**From:** Barry Holden <e.barry.holden@gmail.com>  
**Sent:** 16 August 2018 11:22  
**To:** planning  
**Subject:** Application 3/2018/0638

*Grindleton Parish clerk.*

Drawing Title
**REPLACEMENT GARAGE,
RESIDENTIAL ANNEX STRUCTURE
AND EXTERNAL WORKS:
PROPOSED PLANS, ELEVATIONS
AND SECTIONS**

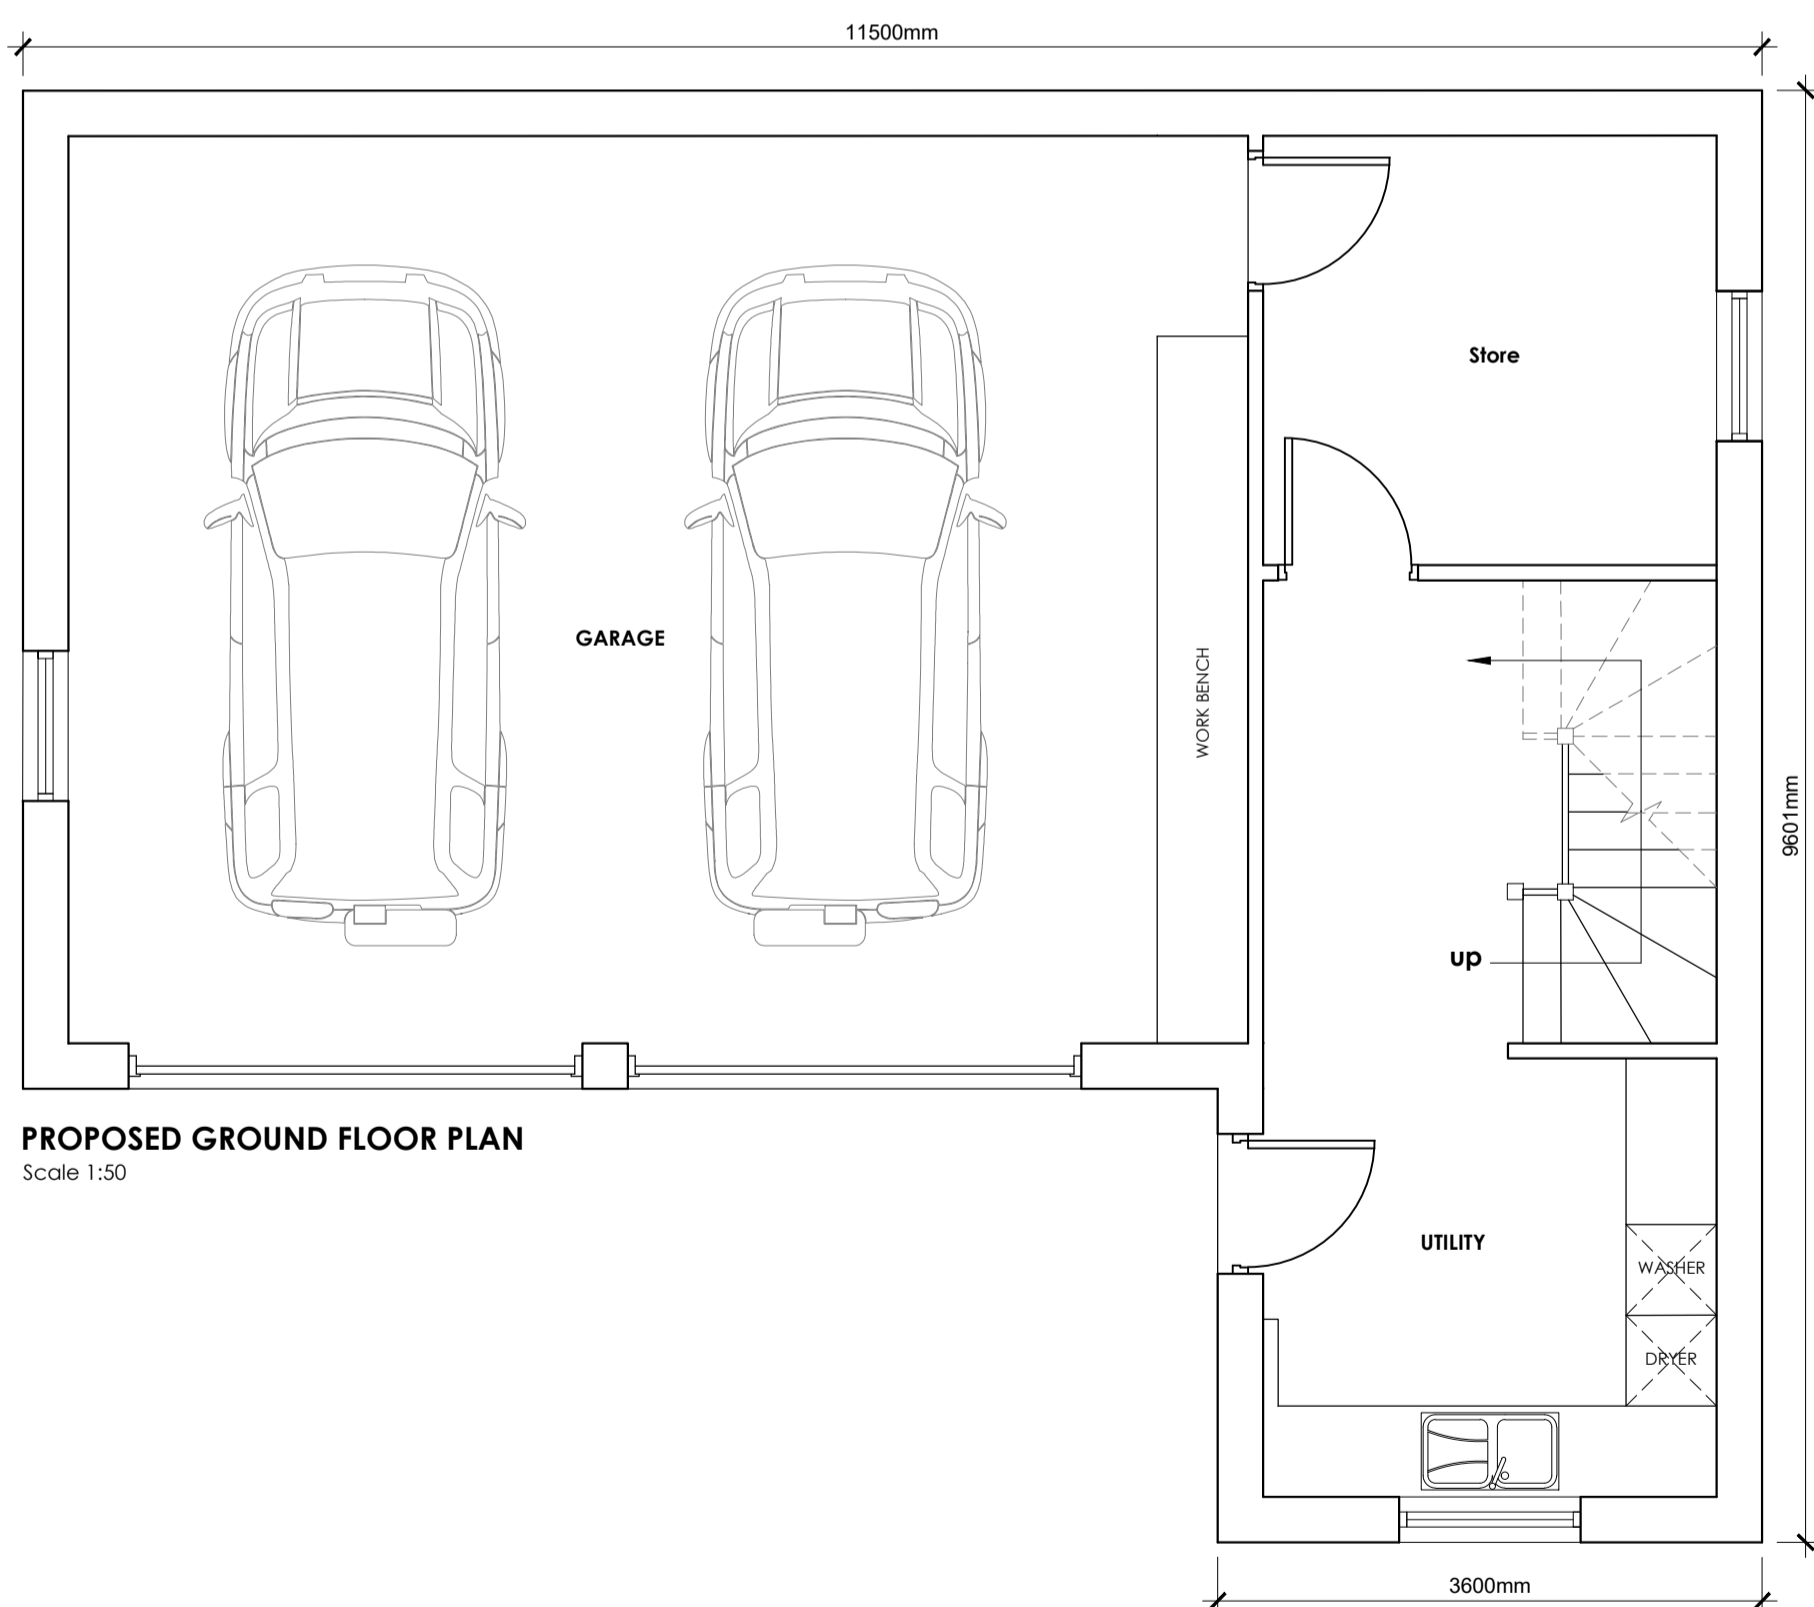
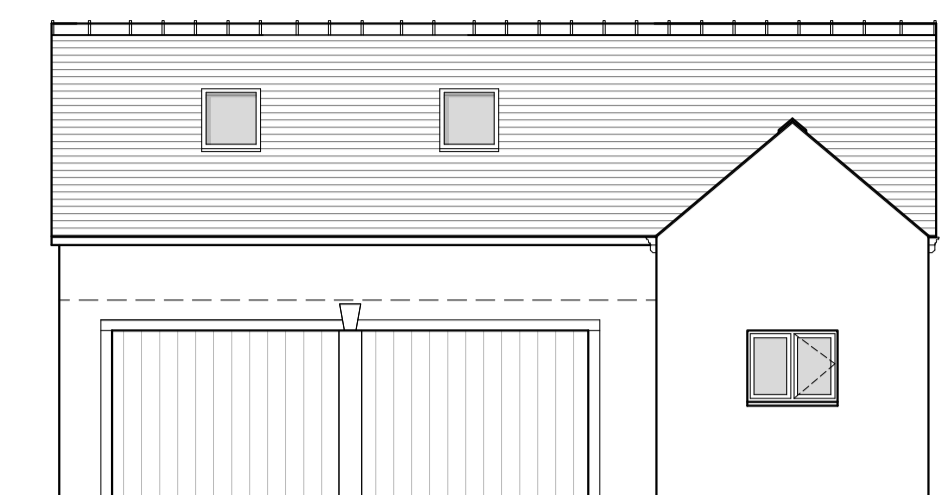
1. Our policy states no new dwellings on Main Street due to existing traffic congestion.
2. We believe this application should be for a second dwelling not a garage. If you put living accommodation in a building is that not a dwelling?
